## SPR EA1N and EA2 PROJECTS

### DEADLINE 2 – COMMENTS ON EXQ1 RESPONSES - 1.10 LANDSCAPE

**Interested Party:** SASES

## **Figure 29.37**

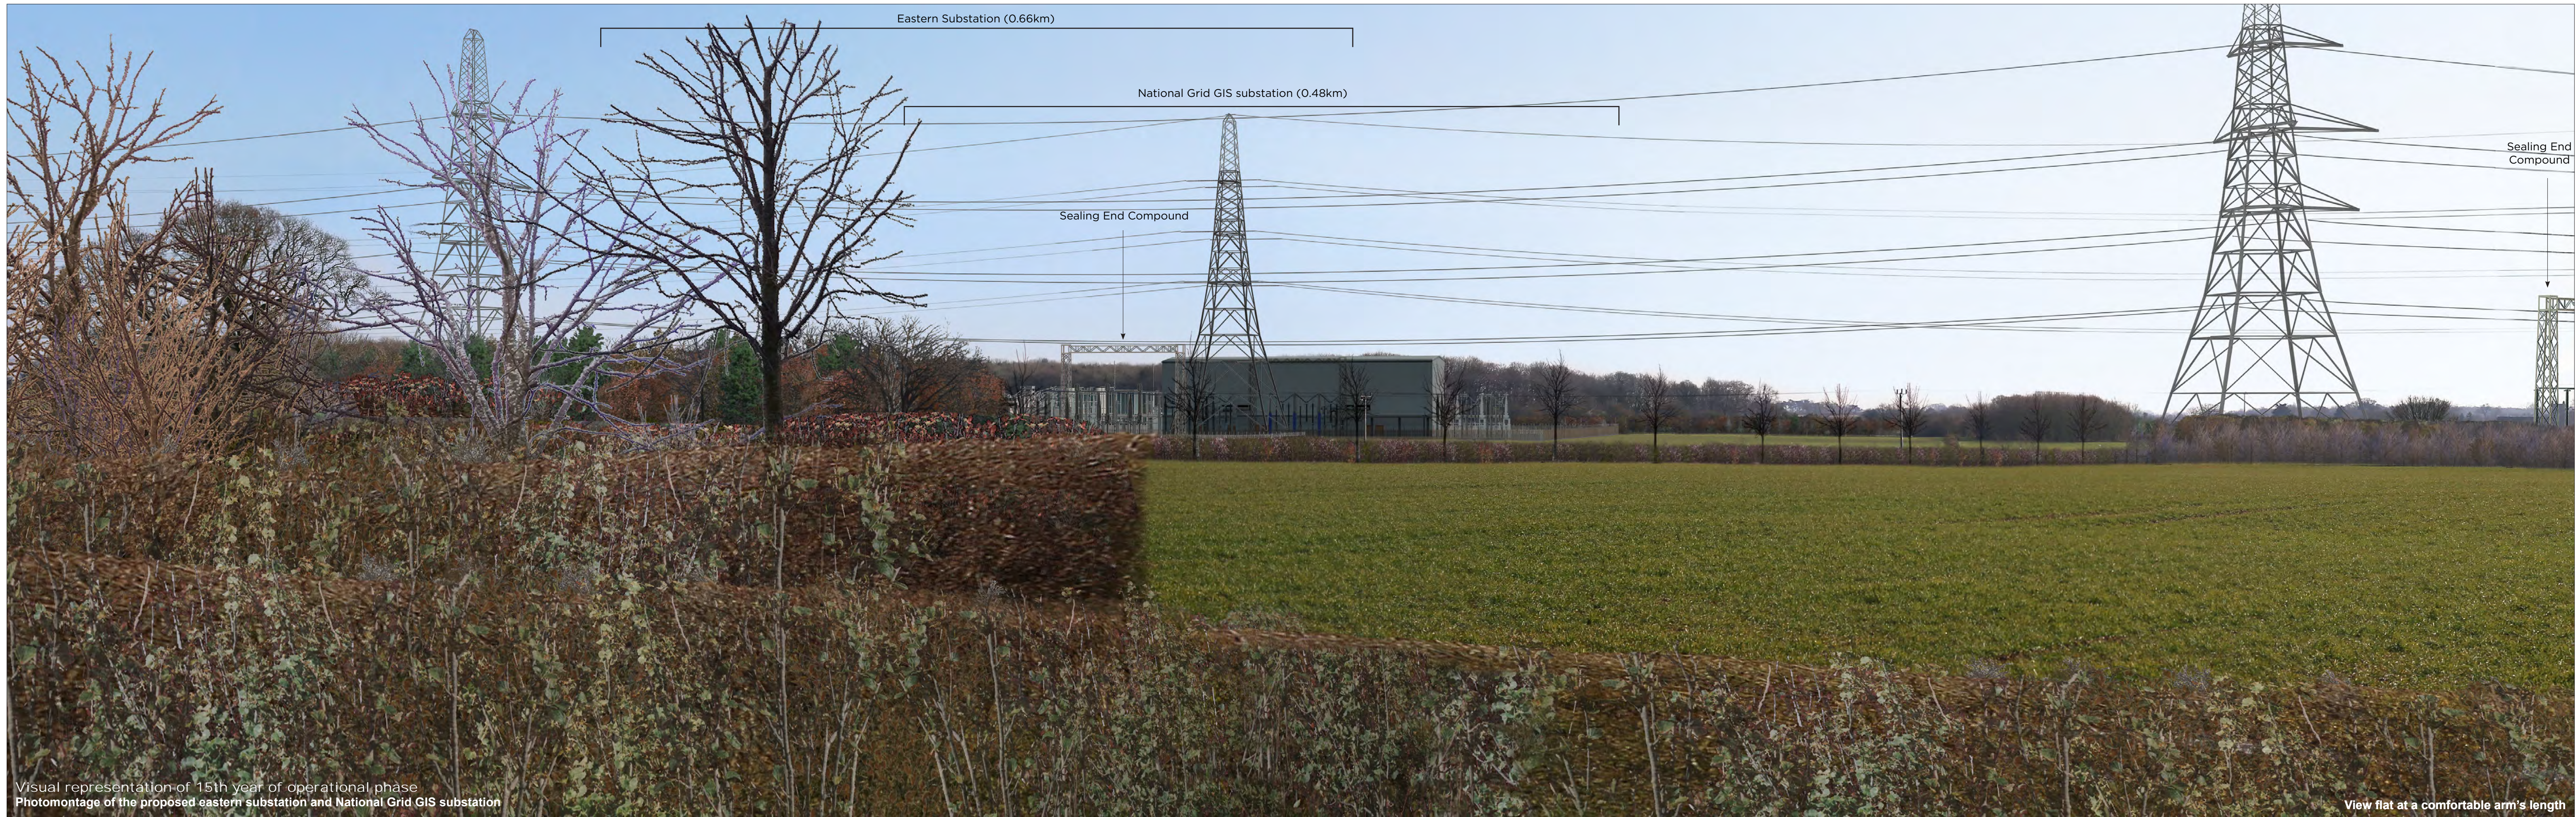
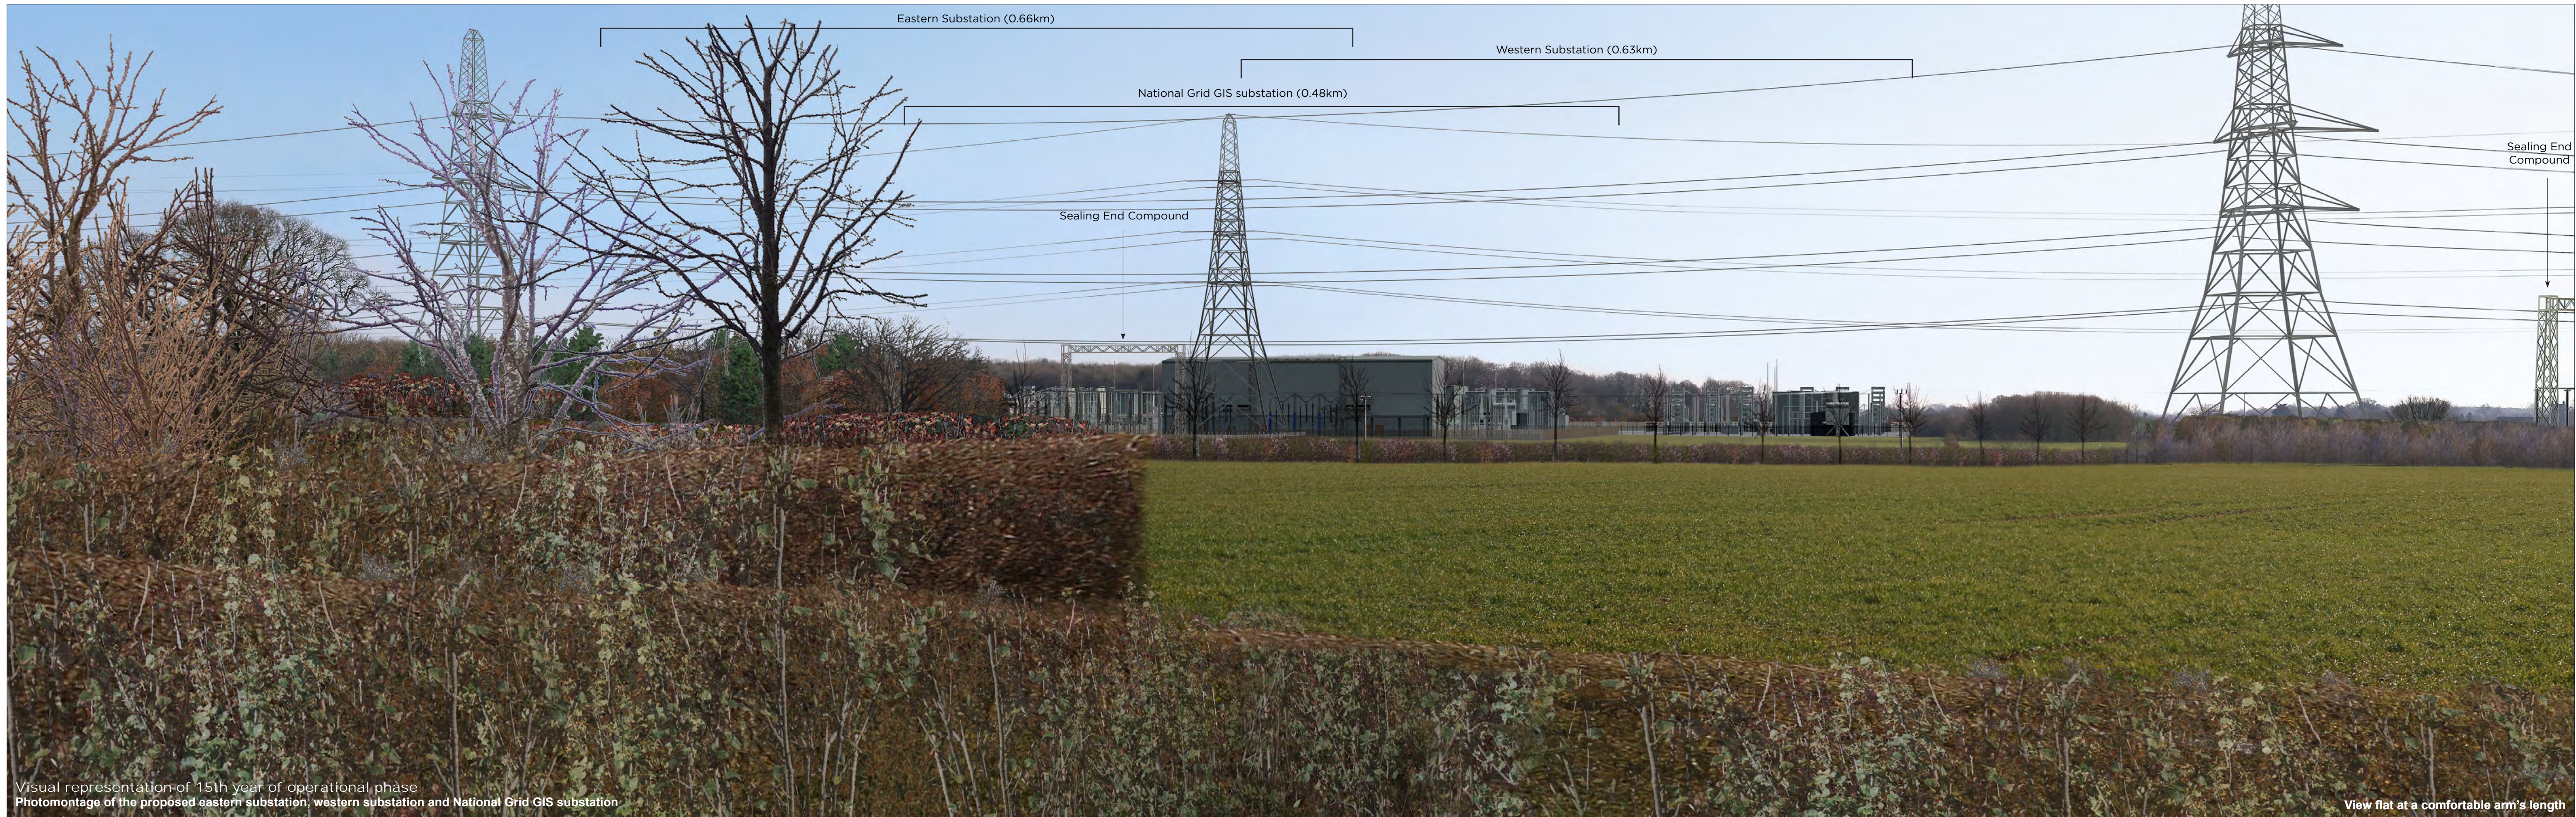
| 1.10.18 | The Applicant | <p>The ExA noted on their unaccompanied site visits [EV-005, EV-006, EV-007] that the eastern side of the property at Moor Farm (NGR TM 41030 61692) has a very open aspect to the south, with open fences and a grassed lawn in front of large windows providing presumably extensive views to the south towards Friston. The applicant is requested to:</p> <ul style="list-style-type: none"> <li>a) Assess the effect of the proposals in the context of the proposed OLMP from this vista</li> <li>b) Can the applicant confirm whether or not this property is</li> </ul> | <i>Not reproduced</i> | <p>The planting will do little to mitigate the impact on this property which will be particularly severe during construction.</p> <p>The growth rates used by the Applicant are optimistic.</p>  |
